Subject: Rezoning Petition Review

Rezoning Petition #: 22-087

Location of Property: Approximately 10.95 acres located on the east side of Mallard Creek Rd, north of Governor Hunt Rd and west of David Taylor Dr.

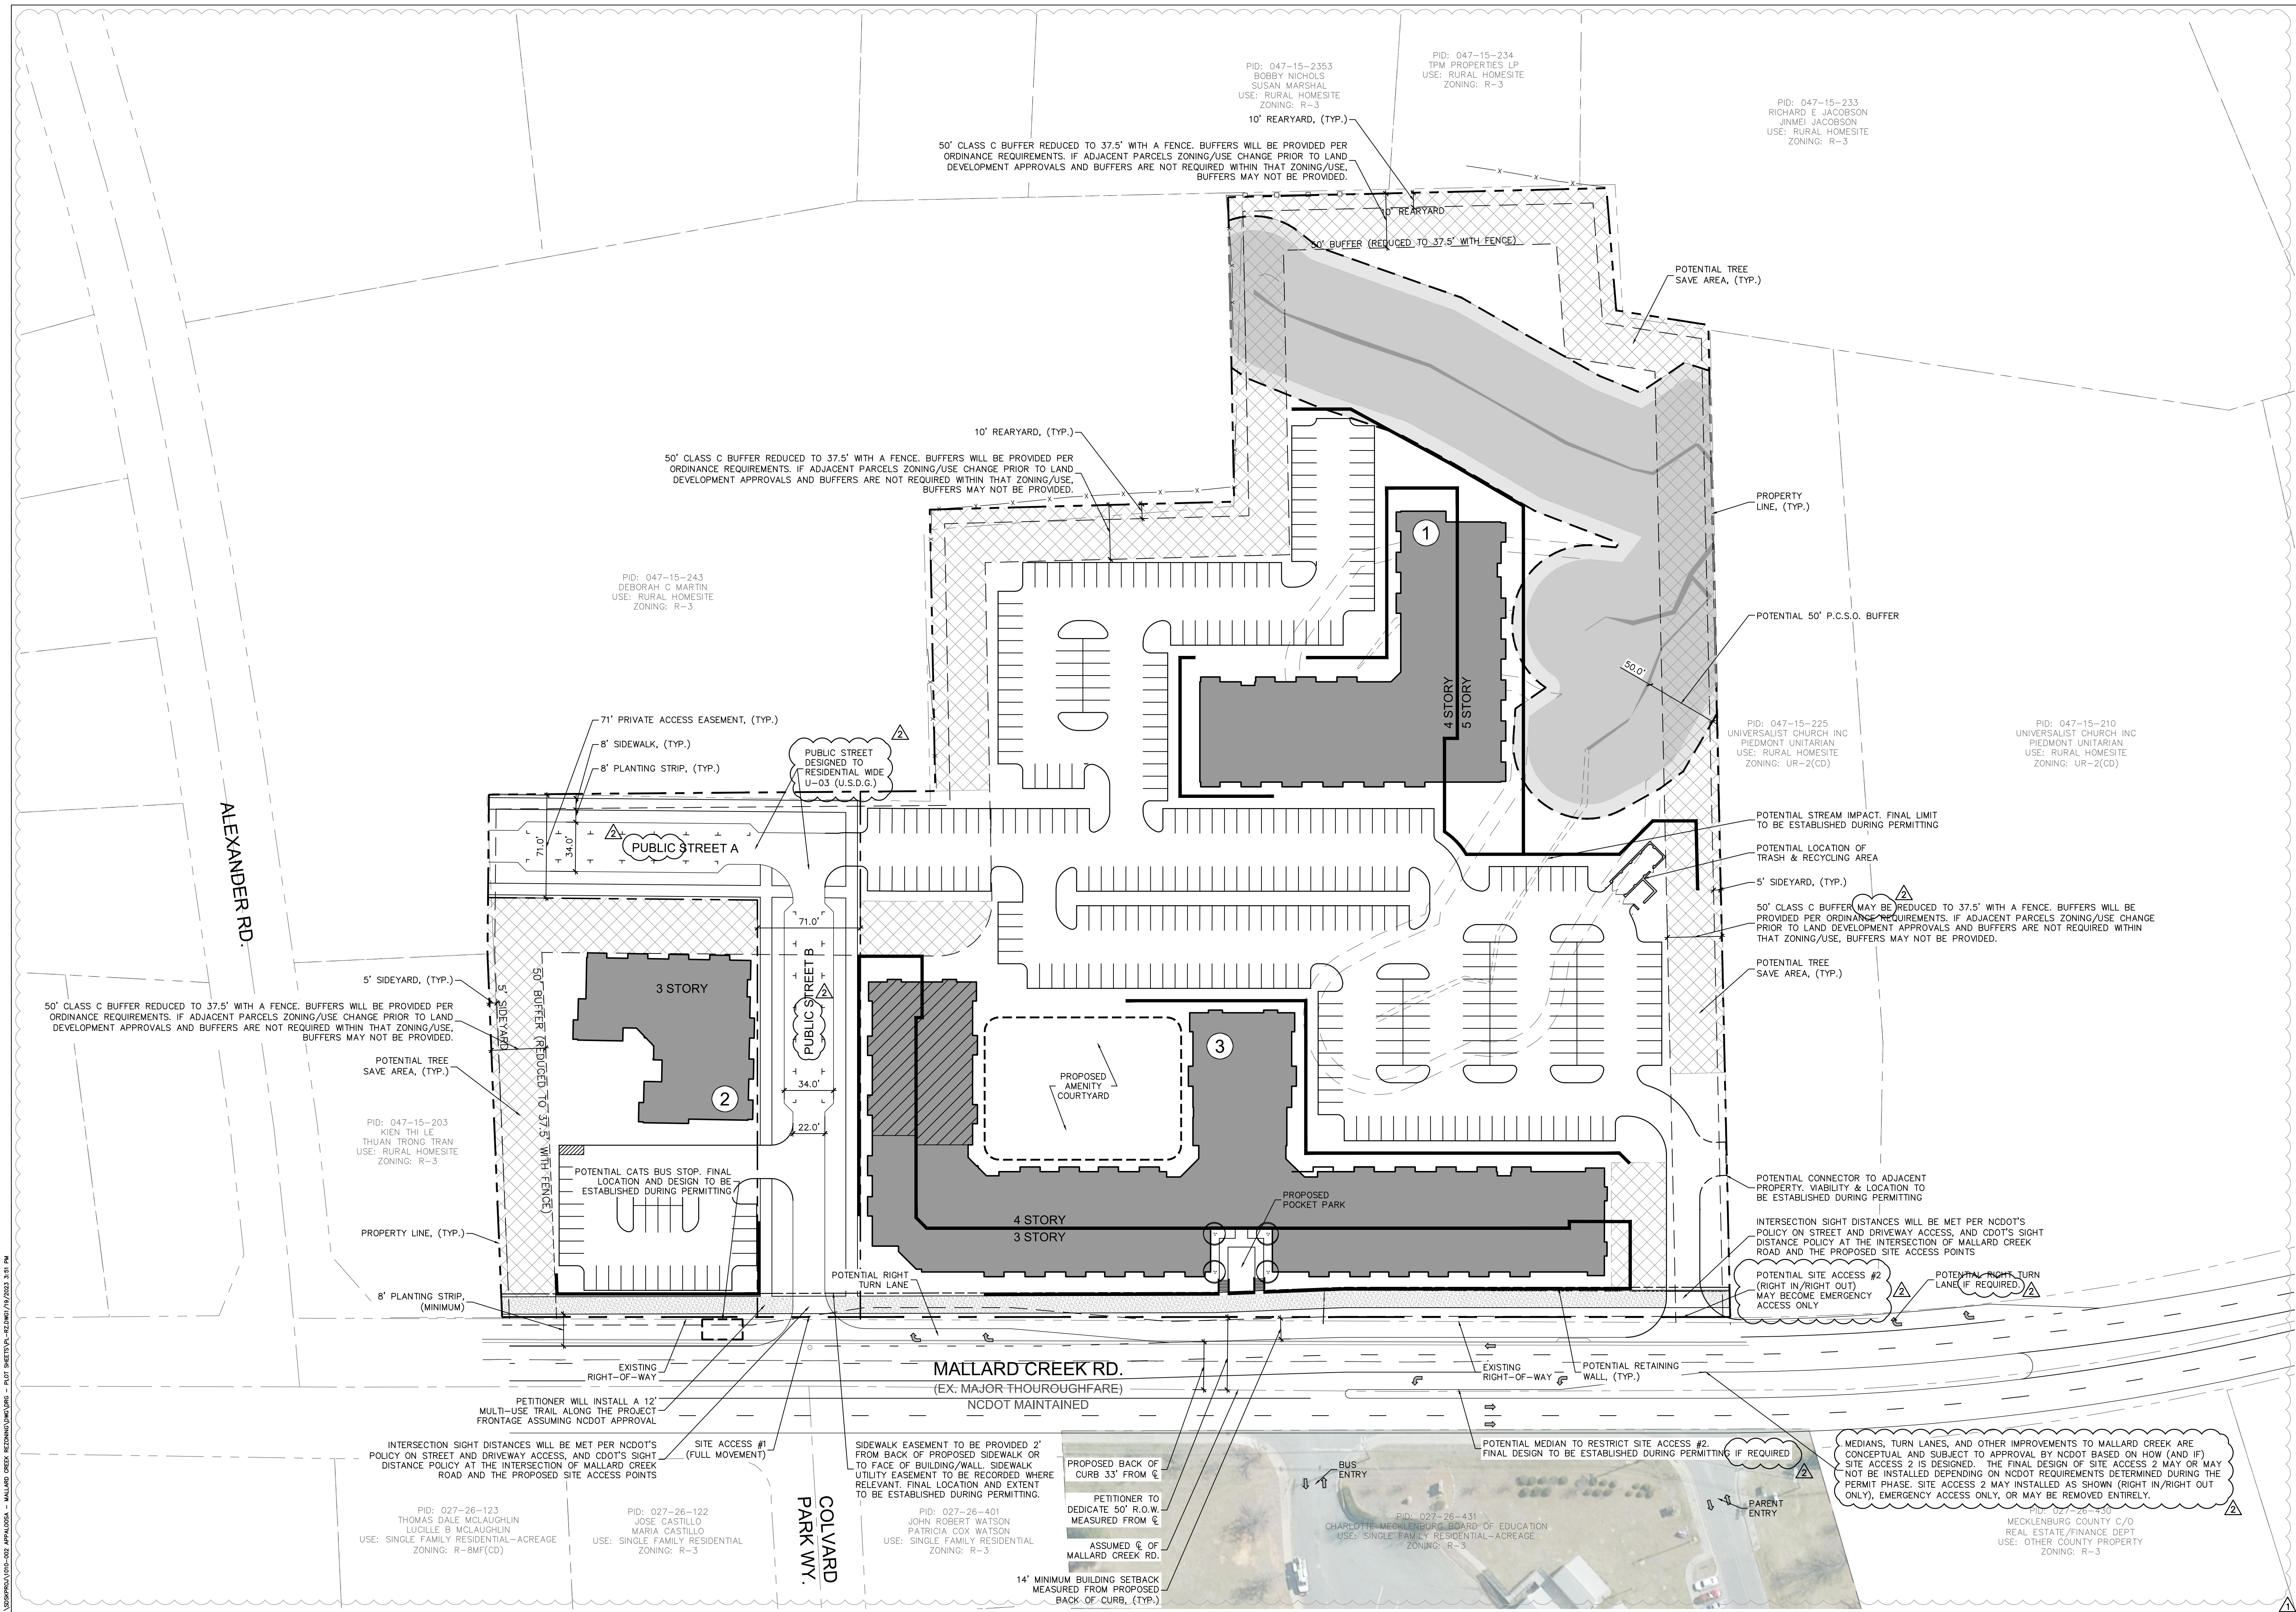
Please label *Potential 50-ft Undisturbed PCSO Buffer* on the site plan. Any increase of impervious area within such buffers may not be allowed and is not approved with the rezoning process. Stream Delineation Reports are subject to review and approval by Charlotte Storm Water Services. Please include the following note under Environmental Features: *“Development within any SWIM/PCSO Buffer shall be coordinated with and subject to approval by Charlotte-Mecklenburg Storm Water Services and mitigated if required by City ordinance. Petitioner acknowledges intermittent/perennial stream delineation reports are subject to review and approval upon submission of development plans for permitting and are not approved with rezoning decisions.”*
